Mr David Gibson  
Team Leader  
Social Infrastructure Assessments  
Department of Planning and Environment  
GPO Box 39  
Sydney NSW 2001

**Lismore Hospital Redevelopment Stage 3C, Uralba Street, Lismore (SSD 8963)  
Notice of Exhibition**

**Figure 3.7: Travel Mode of Staff at the Hospital**

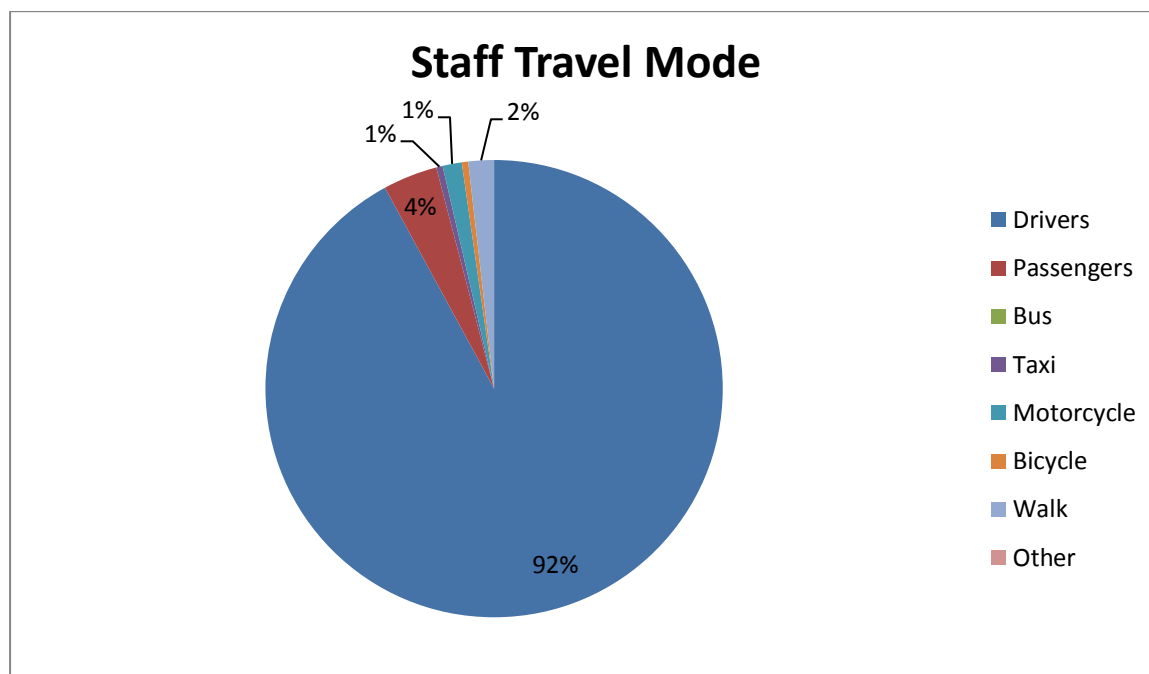
The Transport and Accessibility Impact Assessment prepared by Taylor Thomson Whitting in May 2018, anticipates the proposed development will have a negligible impact on public transport demand. However, the Travel Mode Survey at Section 3.5 undertaken in 2013 only represents hospital staff and not patients. Therefore, the travel patterns concluded from the survey may not illustrate the complete picture.

**Figure 3.10: Bus Route Map**  
 Source: Northern Rivers Buslines

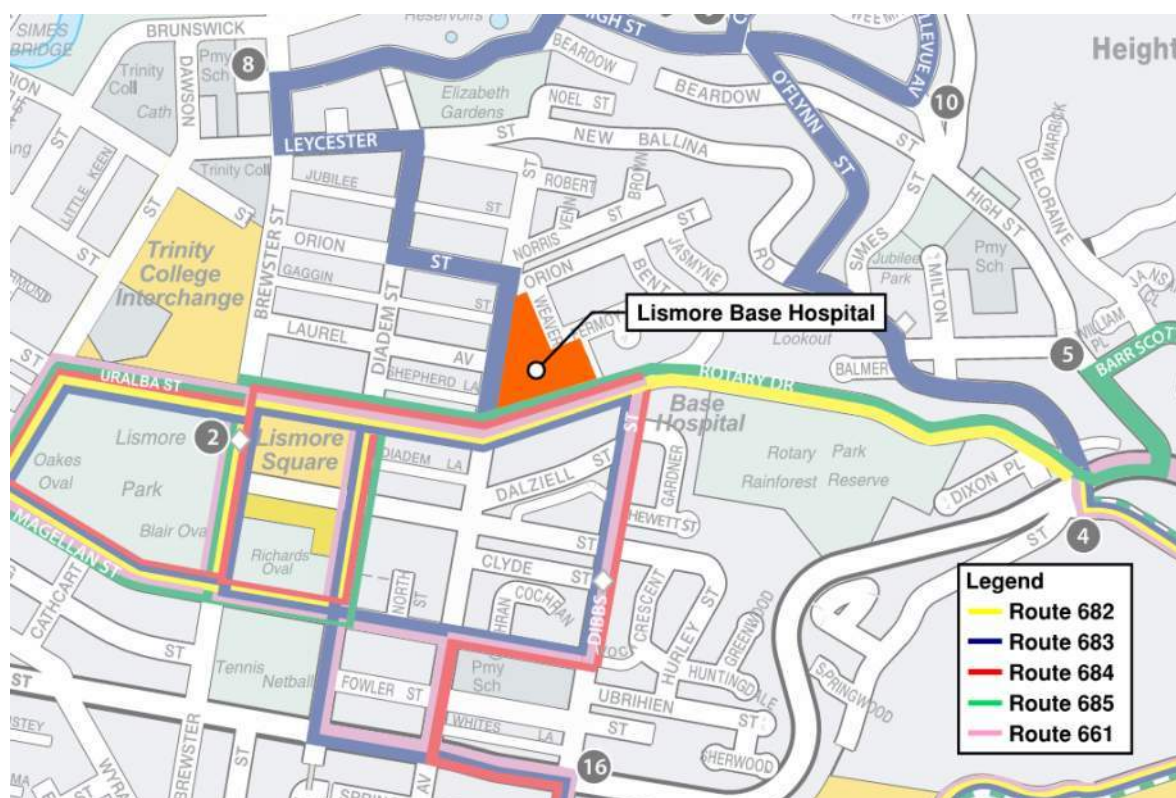
At Section 3.8, the explanation of the "Hail and Ride system" (page.24) is not completely accurate. It should be noted, that while pick-up and drop-off are allowed along the bus route, pick-up and drop-off within formal bus-stop locations is not permitted. On this note, there are two bus shelters on Uralba Street, located near the hospital entrance, both of which are marked on the Hospital Precinct Map at page 98.
